RE: Intake Screening Comments
Project Name: 2436 74TH AVE SE
Project Address: 2436 74TH AVE SE
Building Permit Number: 2310-009

Please see the following itemized responses to the plan review comments.

ABE DIAGRAM A
1" = 10'-0"

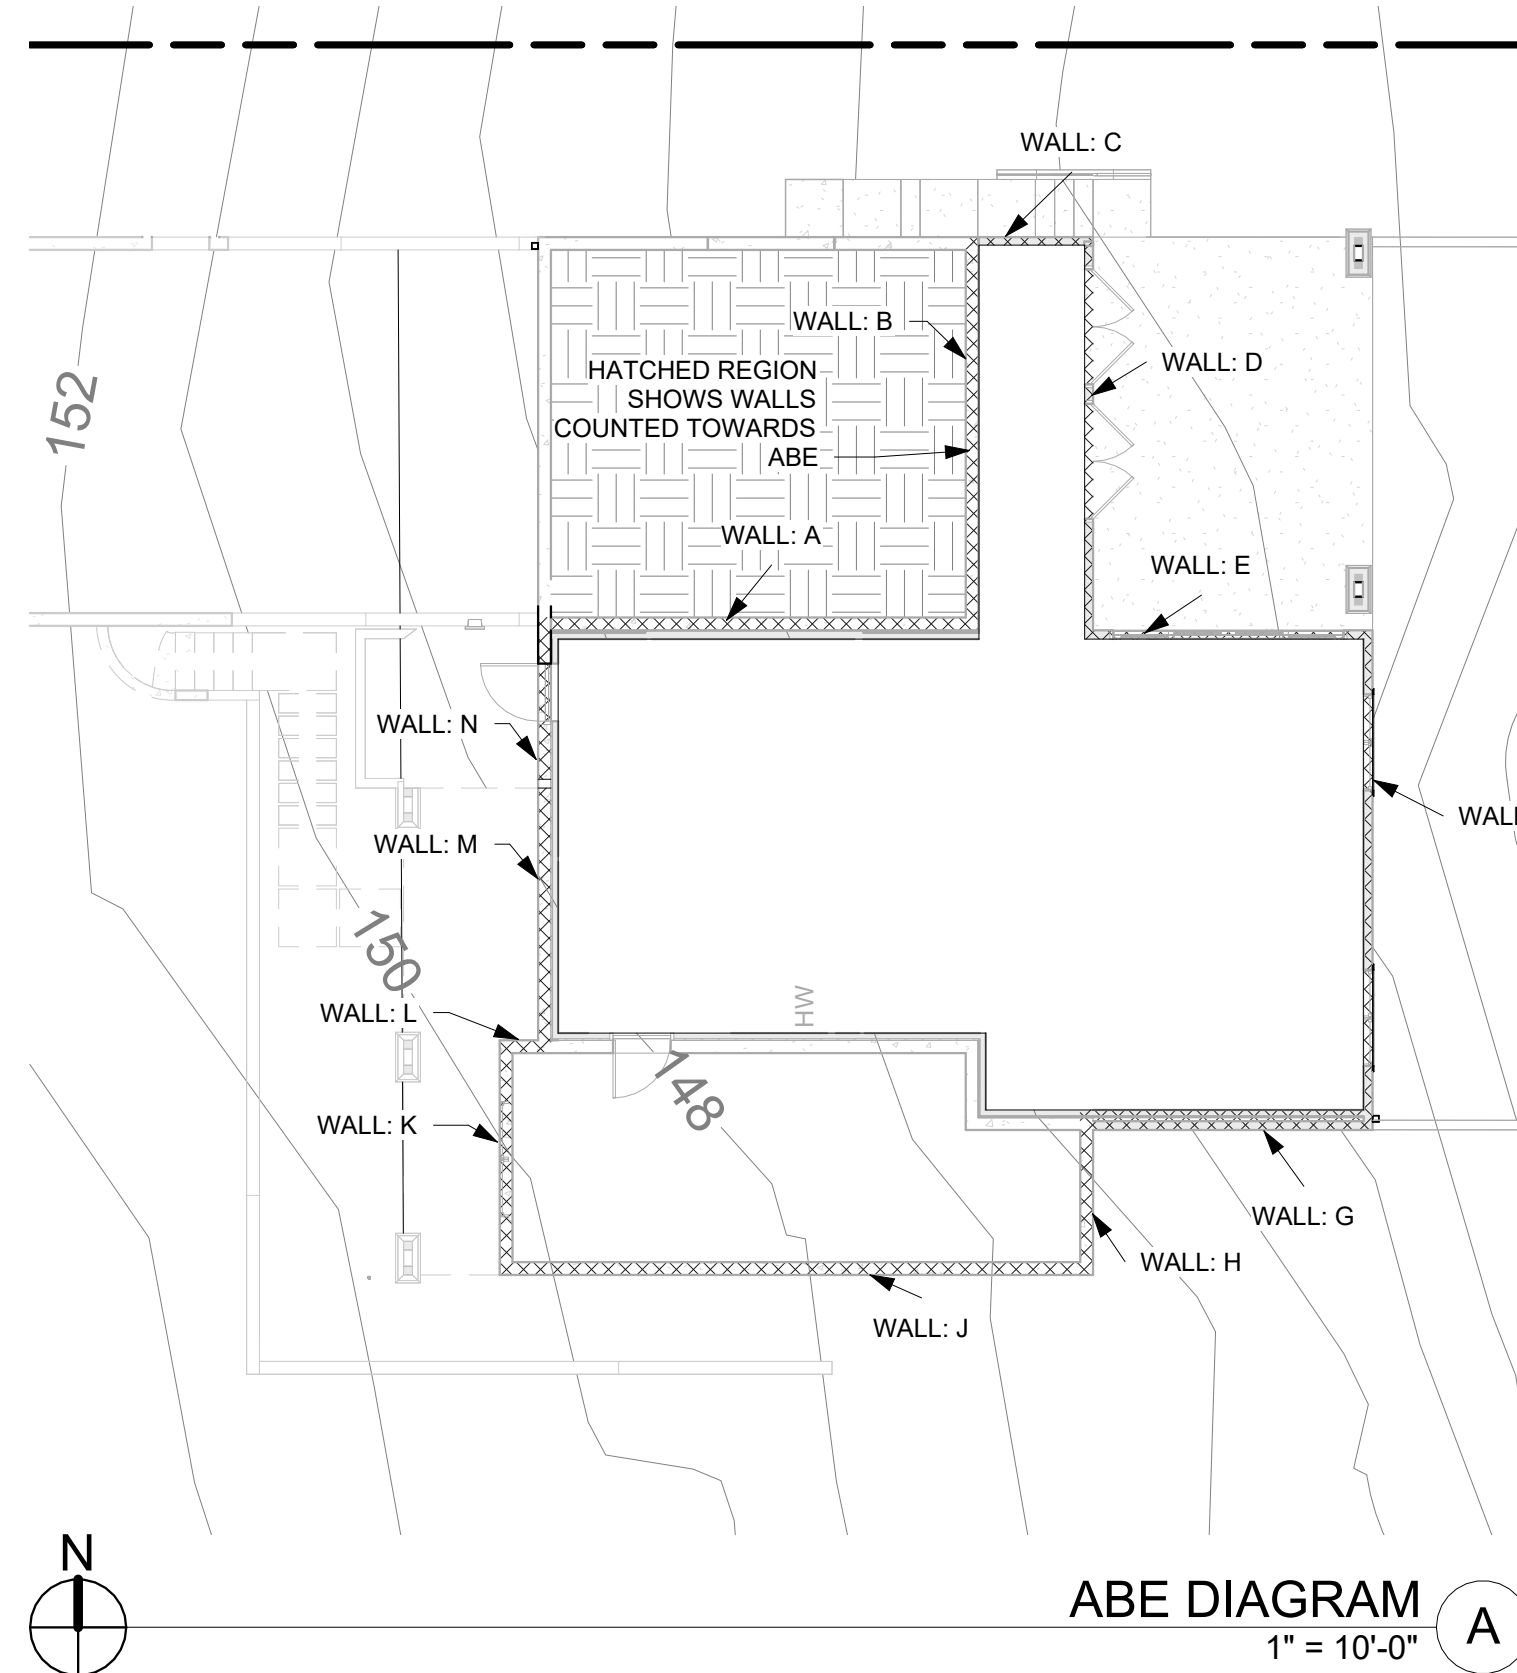
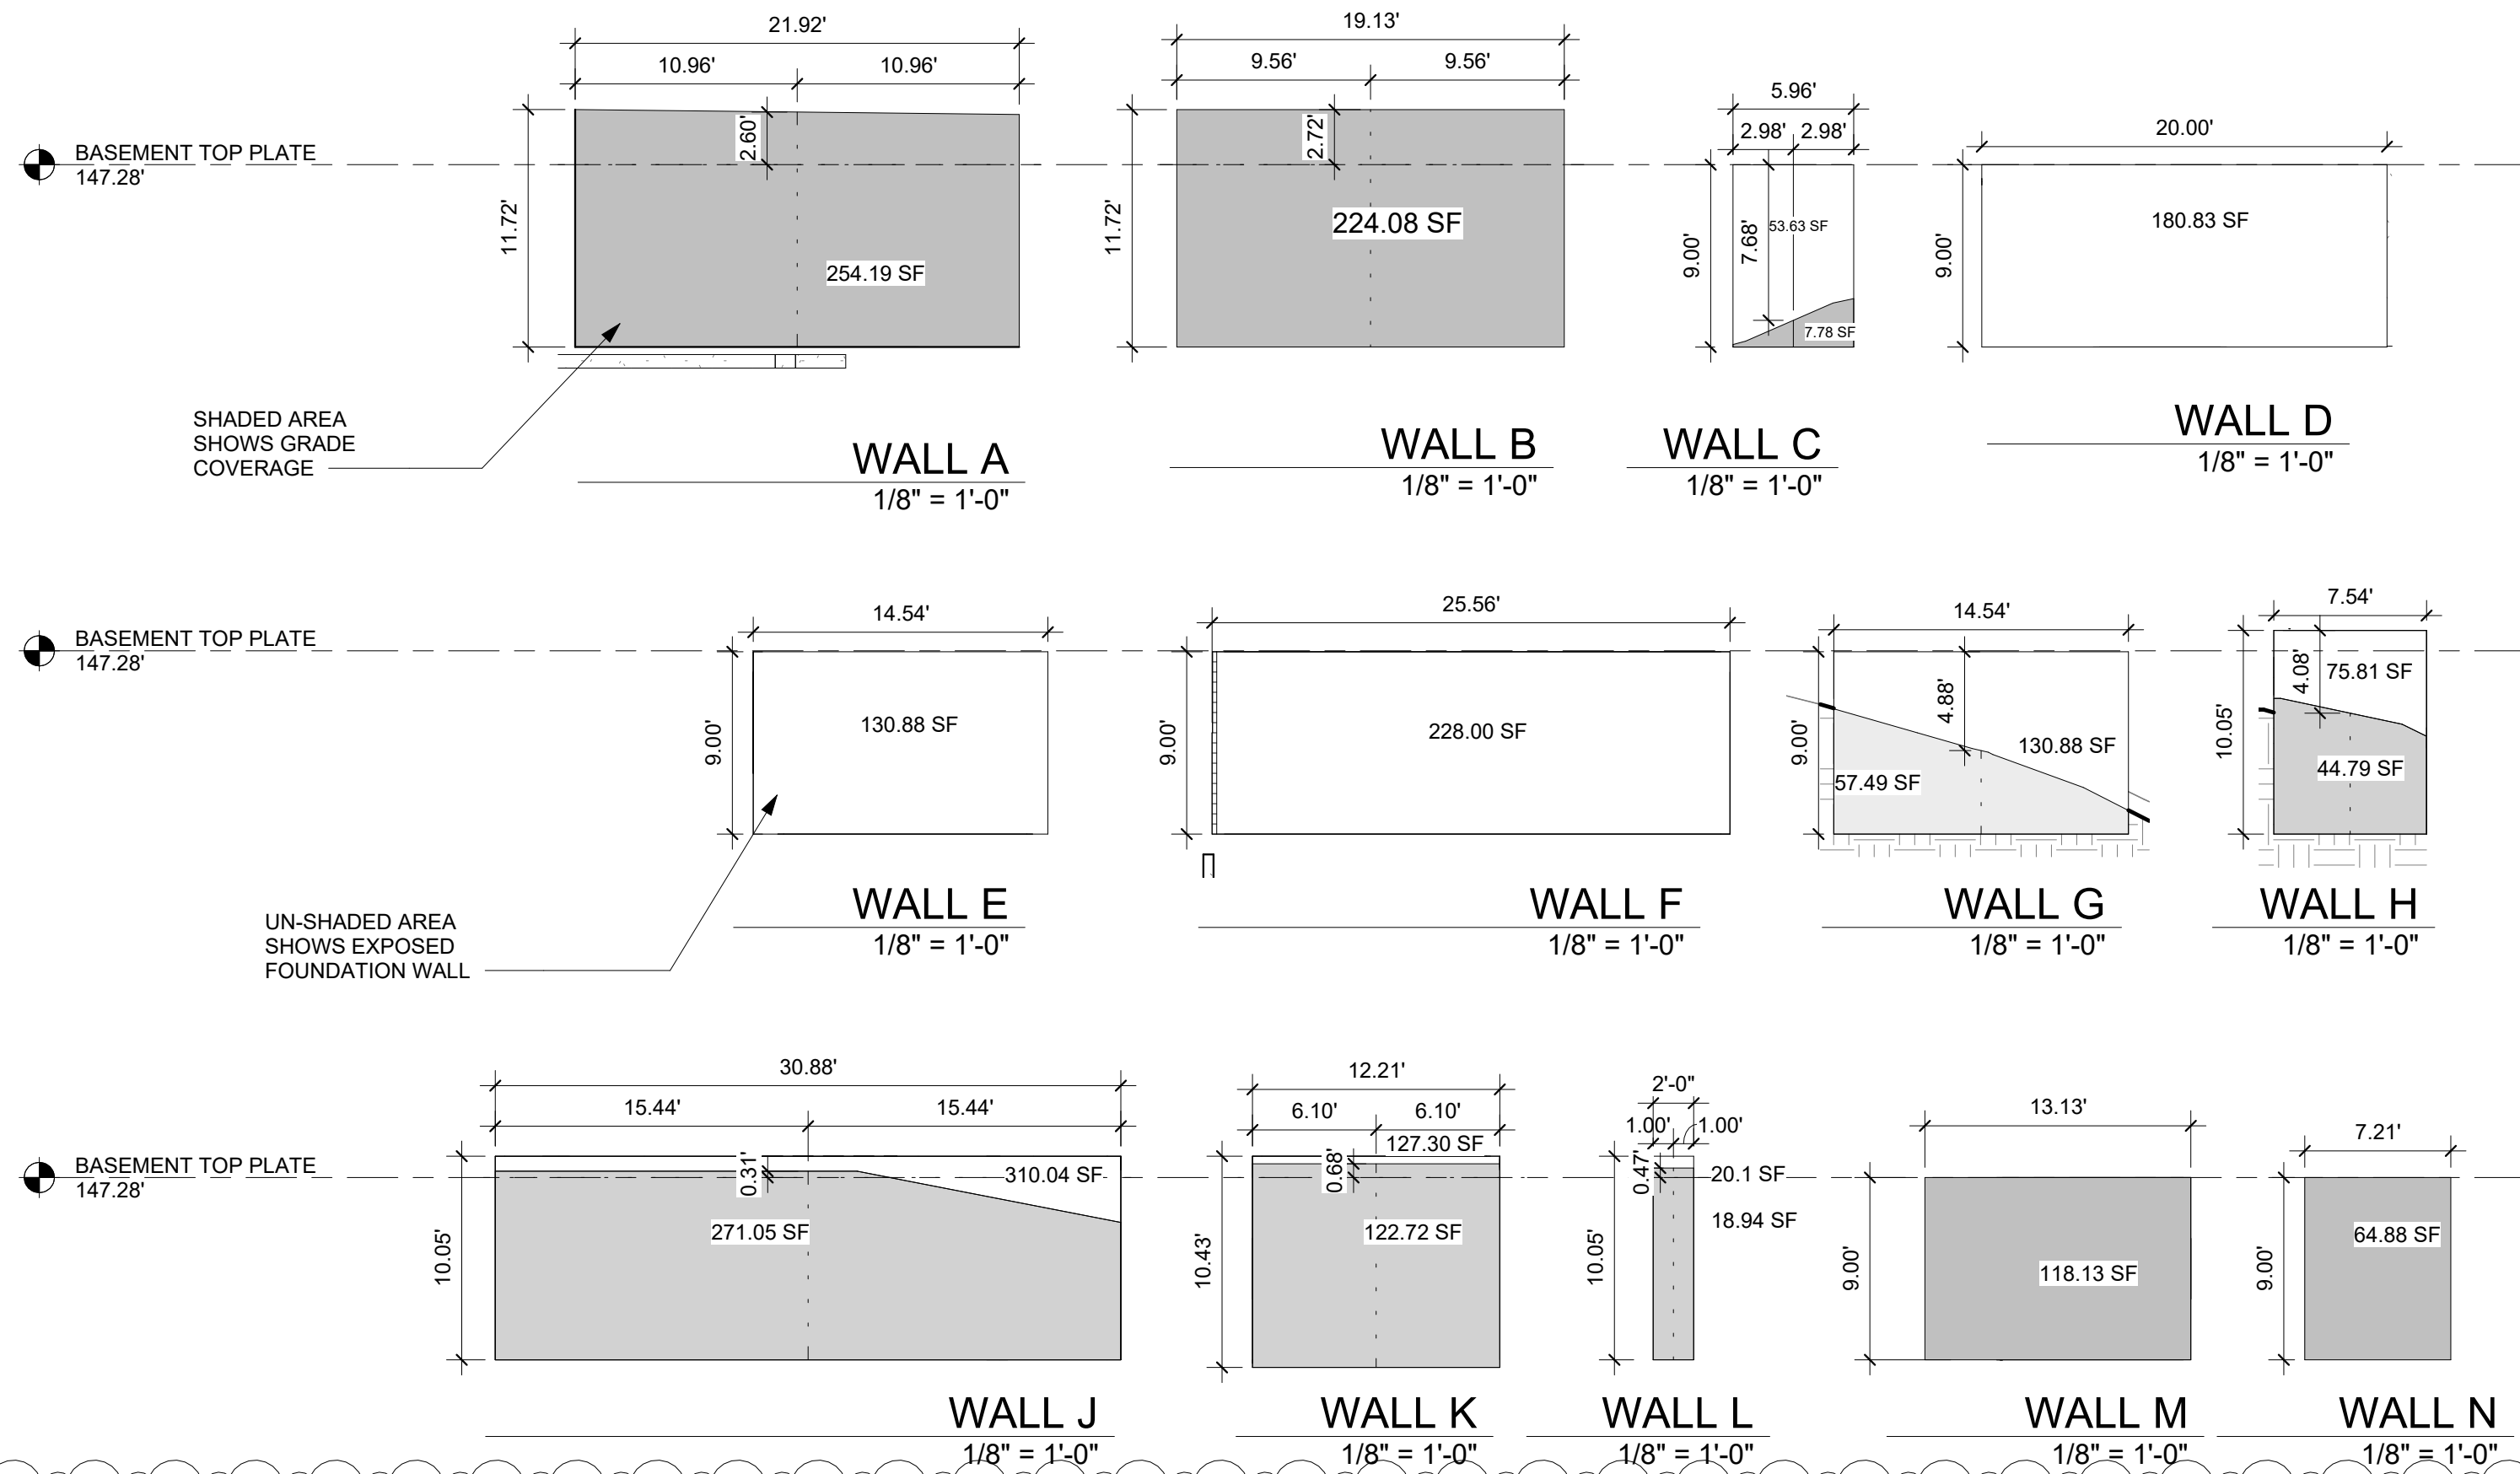
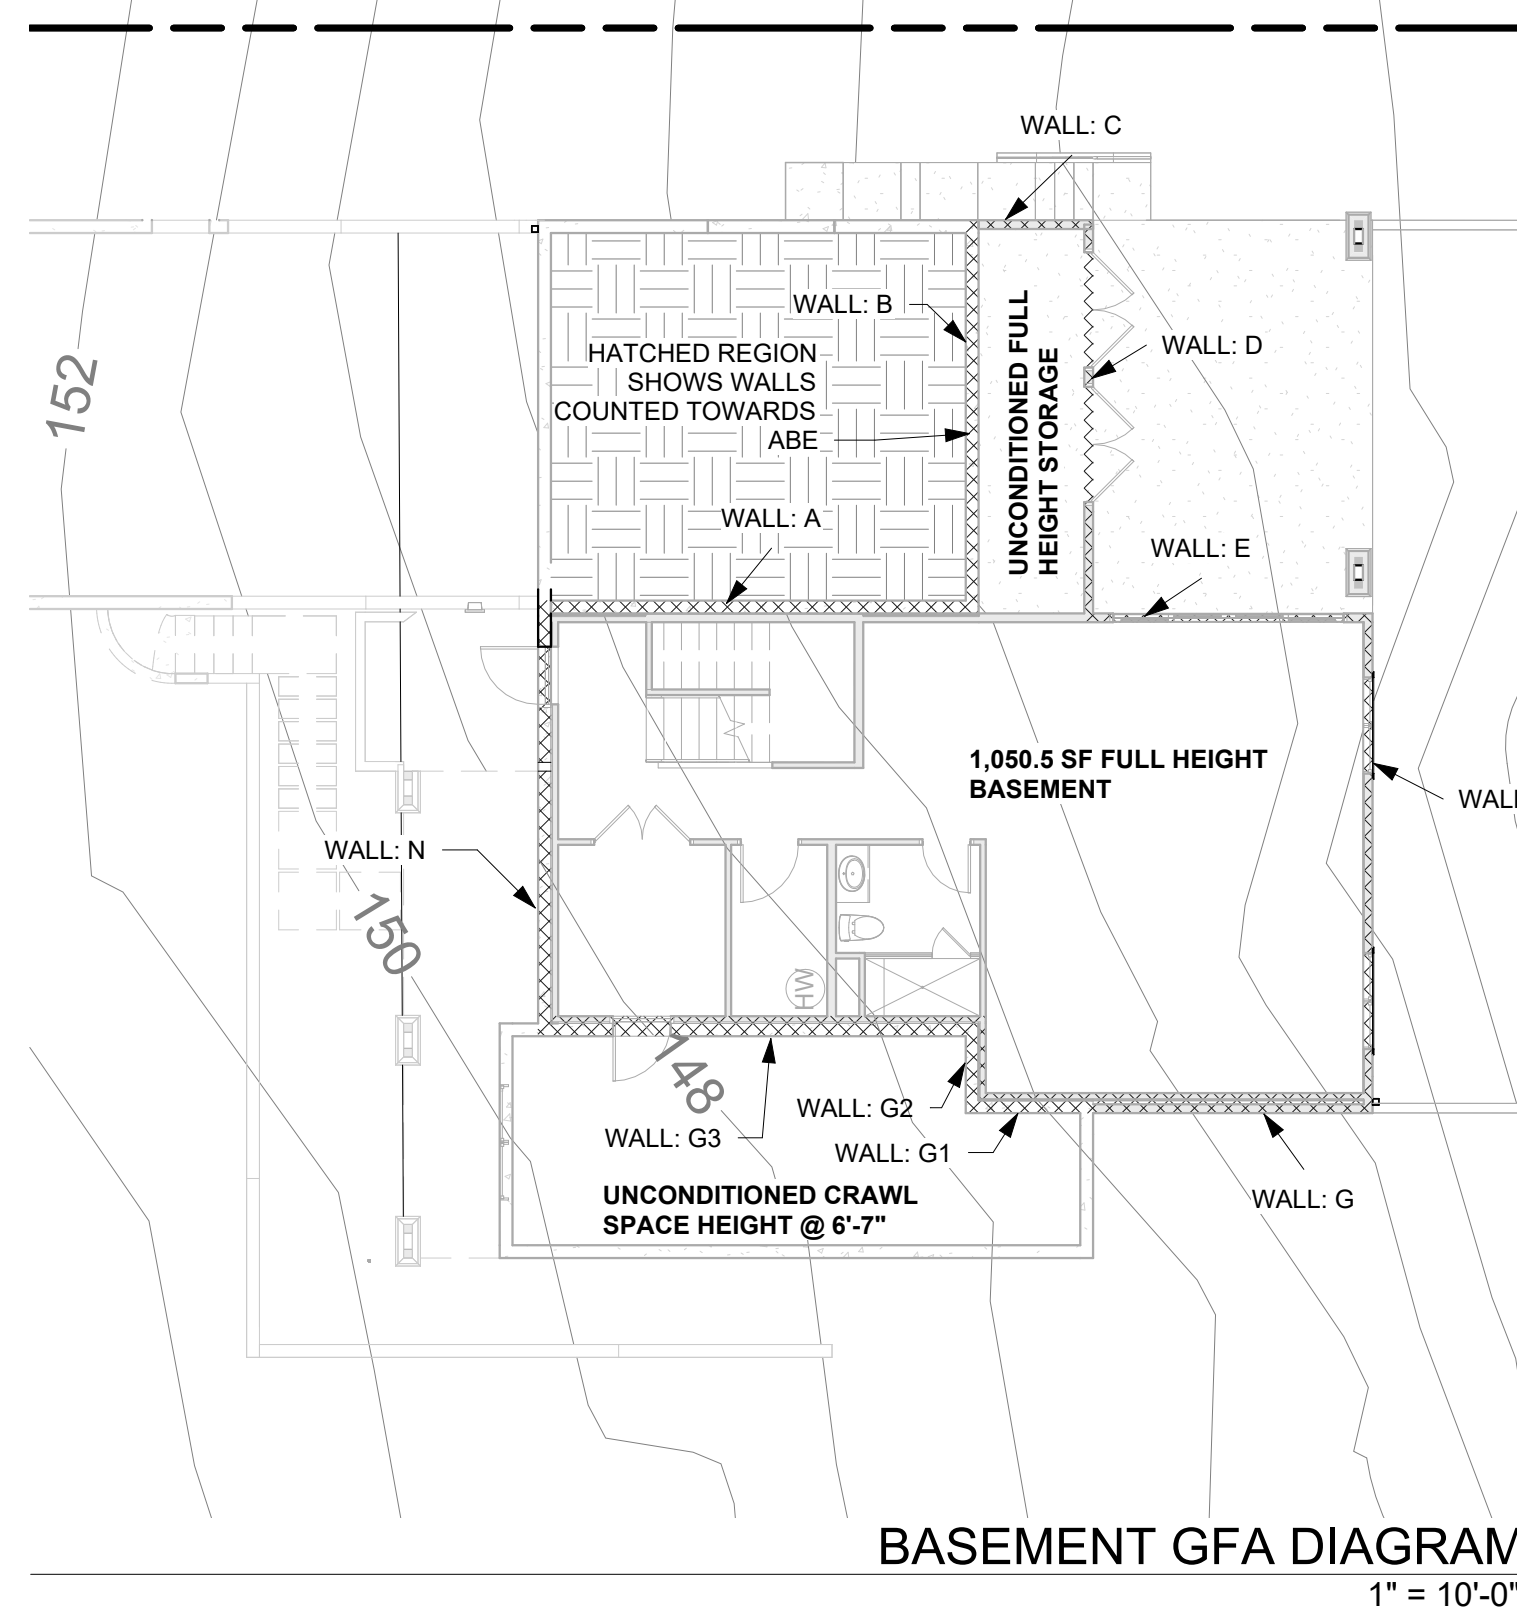
3. MICC 19.09.090(A)(1) requires building pads to be located to minimize impacts on retained trees and critical areas. Please show building pads on the site plan that excludes the driplines of retained trees and that minimizes impacts to critical areas.

Additional diagram has been added to the plan set to show building pad, see sheet A0.3

BASEMENT PLAN D
1/8" = 1'-0"

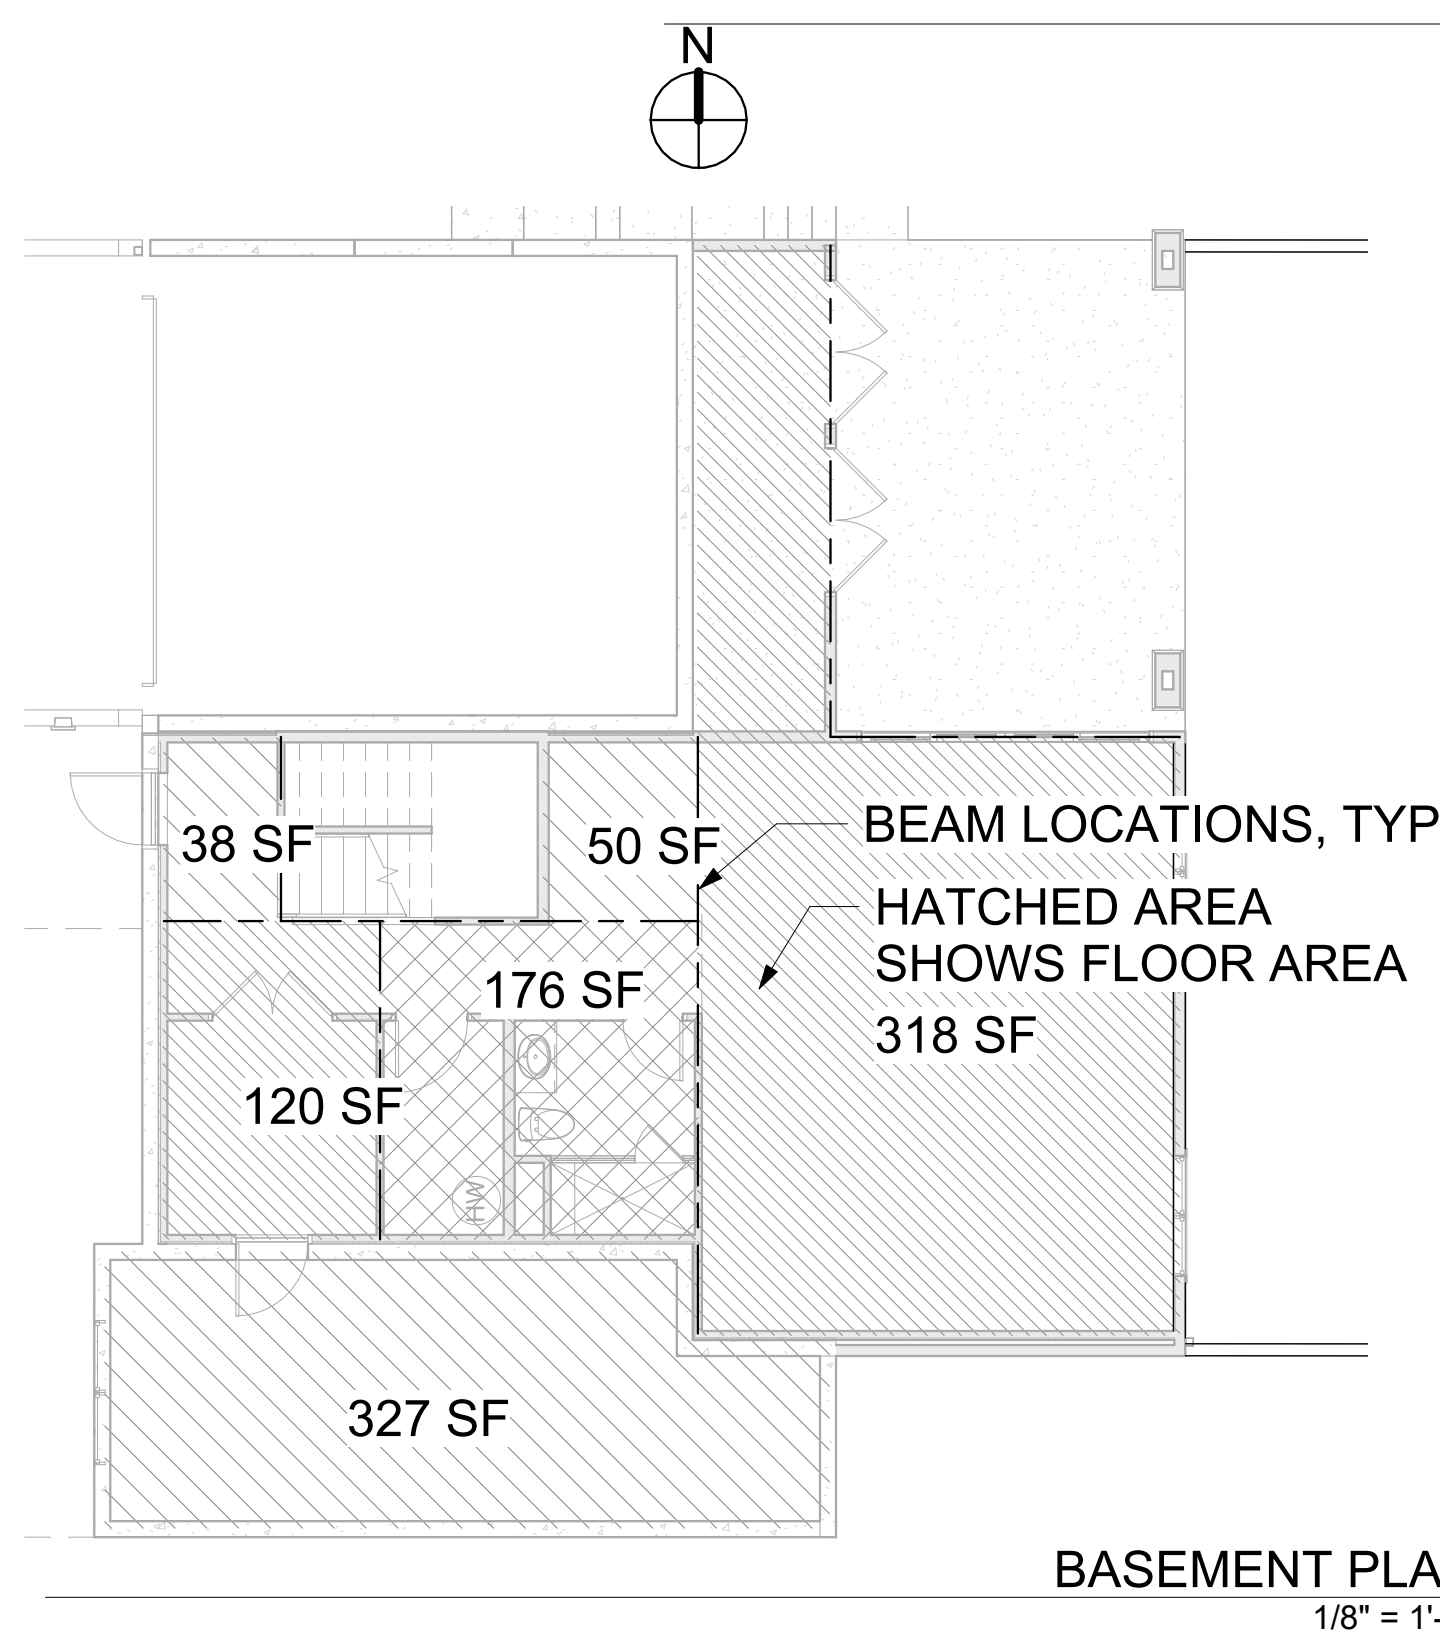
2. The floor plan of the basement appears to show a counter with a sink. Please verify in the plans whether a portion of the basement will be used as an accessory dwelling unit. If there will be an accessory dwelling unit in the basement, please submit a separate land use application for an Accessory Dwelling Unit permit.

Counter and sink have been removed from basement, see sheet A2.0.
